**September 12, 2019**

Orleans Heights Development  
 Madison Centre  
 4950 Yonge Street  
 Toronto ON  
 M2N 6K1

**Subject: 3030 St. Joseph Boulevard  
 Residential/Commercial Development Proposal  
 Response to City Questions on Transportation Brief**

SP-1

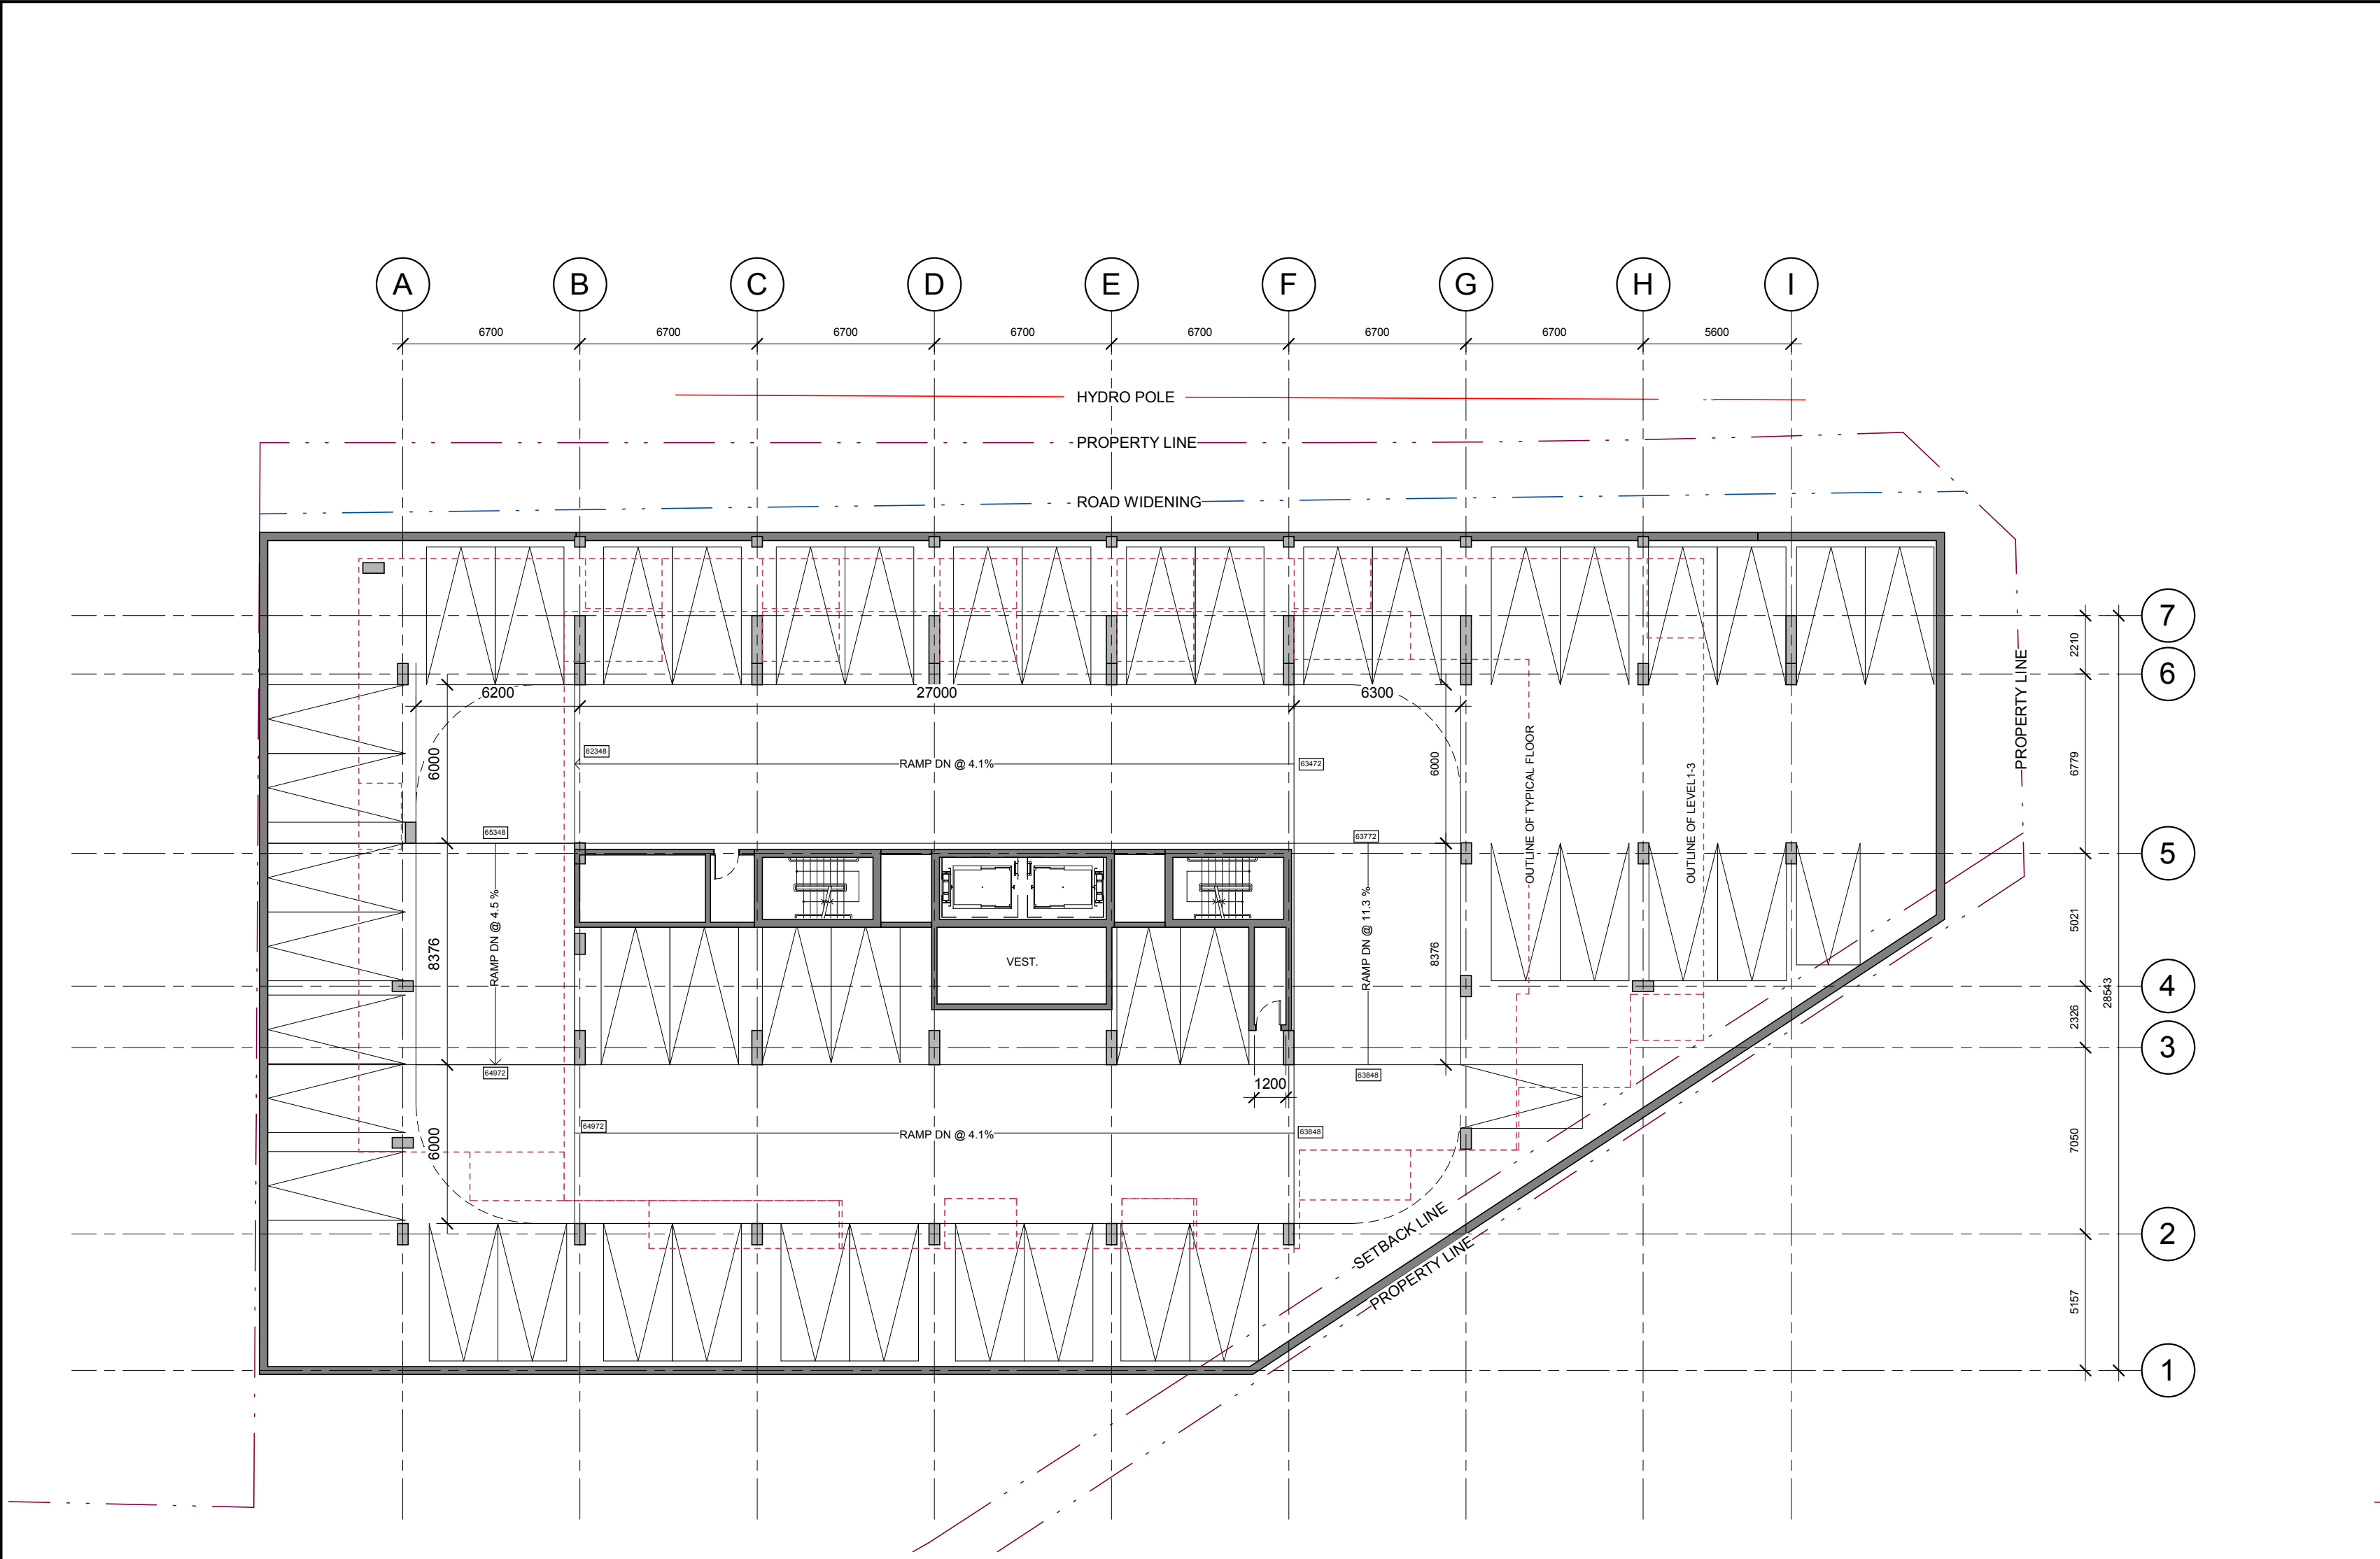
Comment 2: Can the existing raised median in St. Joseph Boulevard be extended west past the proposed site driveway to physically restrict in the right-in/right-out only movements.

*Response 2: The existing raised median in St. Joseph Boulevard ends approximately 15m to the east of the proposed site driveway(see Attachement). The median then extends west past the subject location as a painted median which tapers down from east to west. At the location of the proposed site driveway the curb to curb cross-section of St. Joseph Boulevard is approximately 19m, comprised of a 1.5m painted median and four traffic lanes ranging in width from 3.5m to 3.65m. To extend the raised median west past the proposed site driveway, the raised median width should ideally be 1.5m wide with a 0.25m offset from the adjacent lanes. Given the existing cross-section, it appears that there is sufficient curb-to-curb width to accommodate the raised median extension. It would be accomplished by narrowing up the traffic lanes slightly, and possibly reducing the median extension width slightly. Narrowing the lane width can be accomplished by redoing the line painting. The raised median could be extended approximately 2 or 3m past the property line without adversely impacting access to the adjacent site to the west. As the proposed site-driveway is located approximately 6.0m east of the property line. The proposed raised median extension would extend approximately 8m to 9m west beyond the site driveway.*

*It should be noted that a raised median extension would be a project cost.*
